Reference: H01-1012-25
Proposal: Proposed single storey side extension to bungalow to form attached garage & external alterations - Retrospective
Location: 186 Barrier Bank Cowbit Spalding
Applicant: Mr P Fox

Acceptance of Amendment Number 1

PROPOSED ELEVATIONS

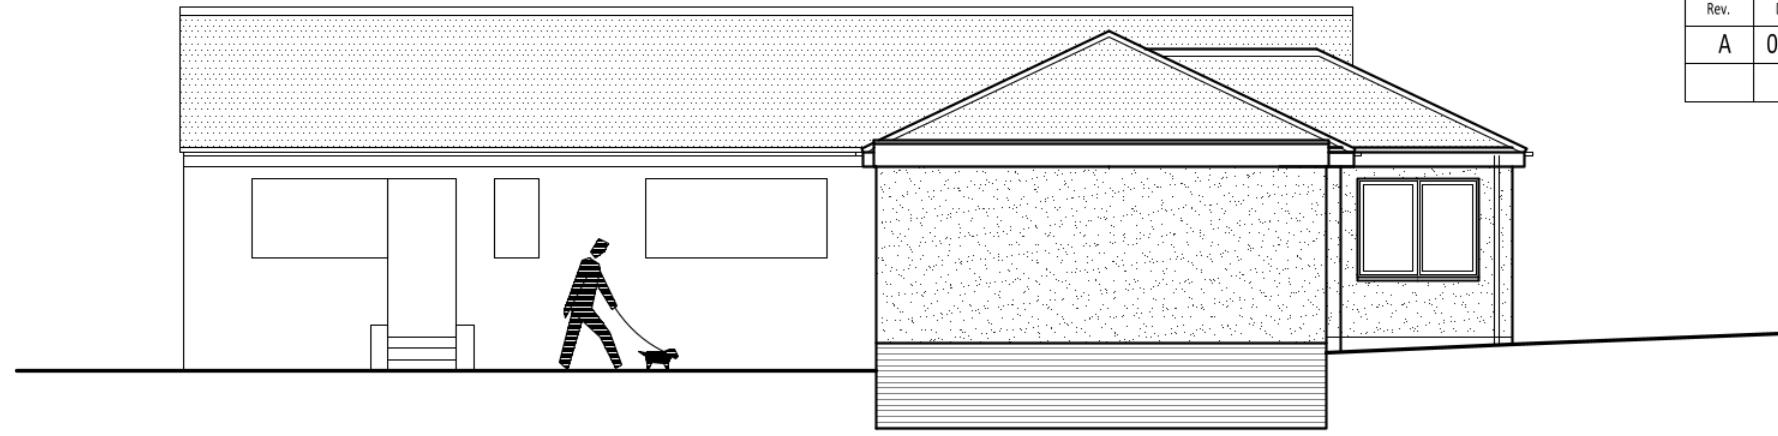
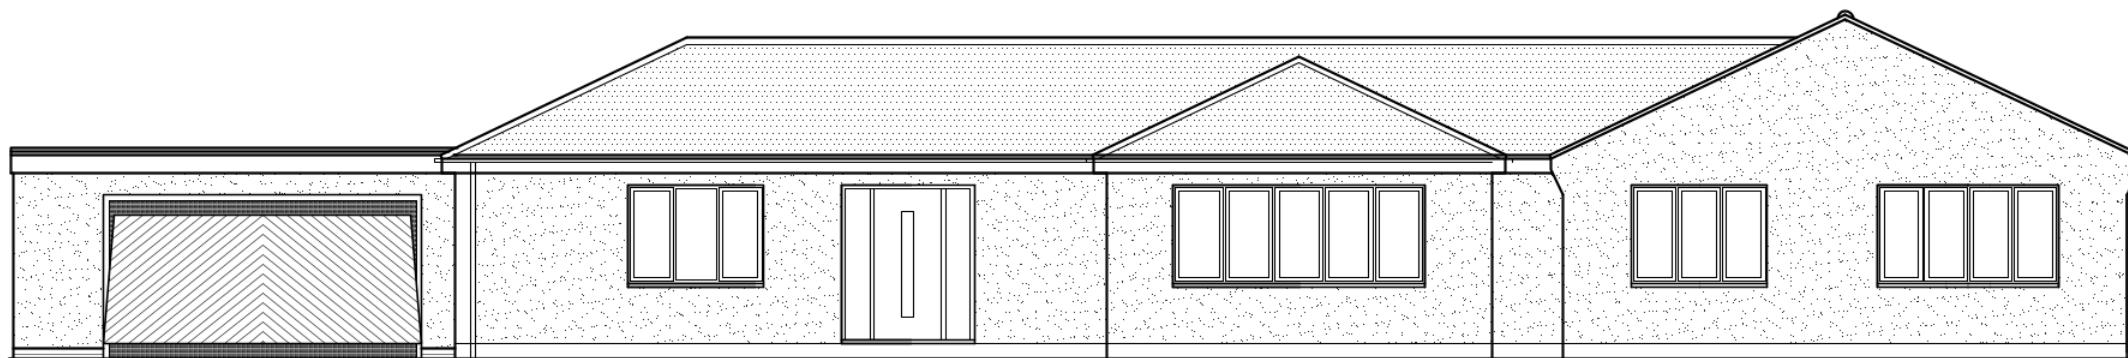
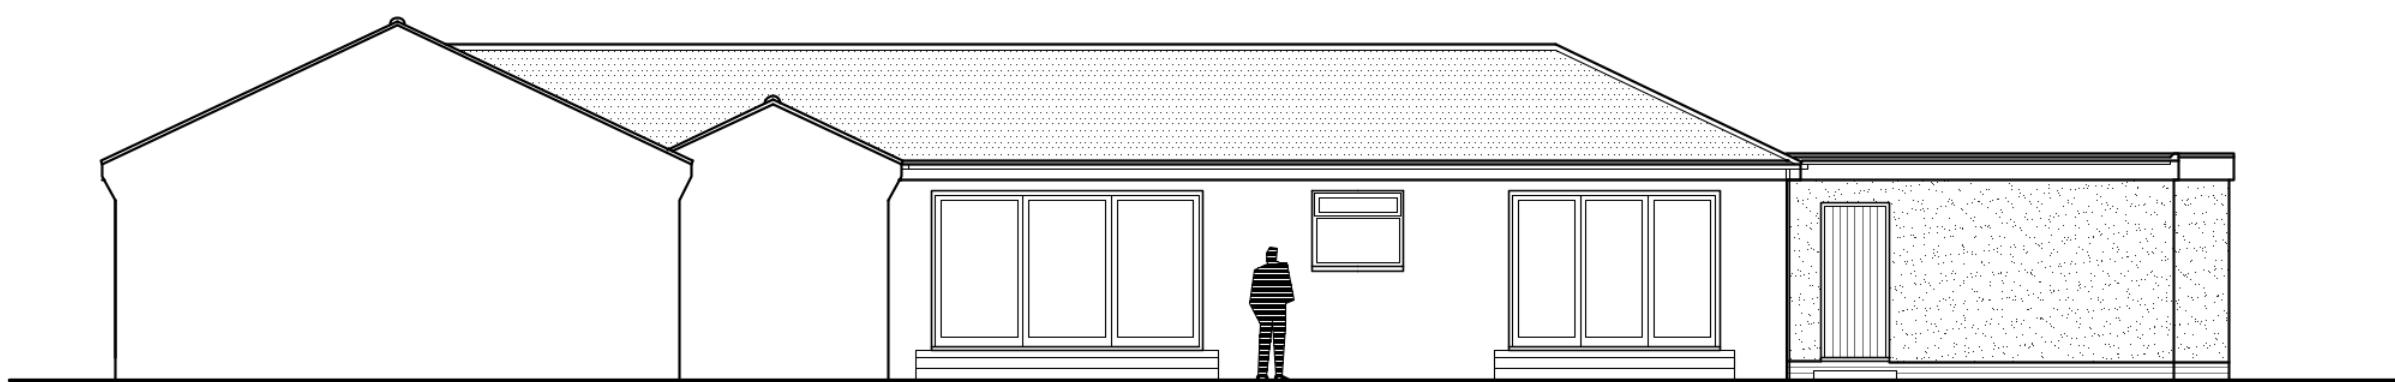
Change of external wall materials to bungalow and extension from brick and false stone to render
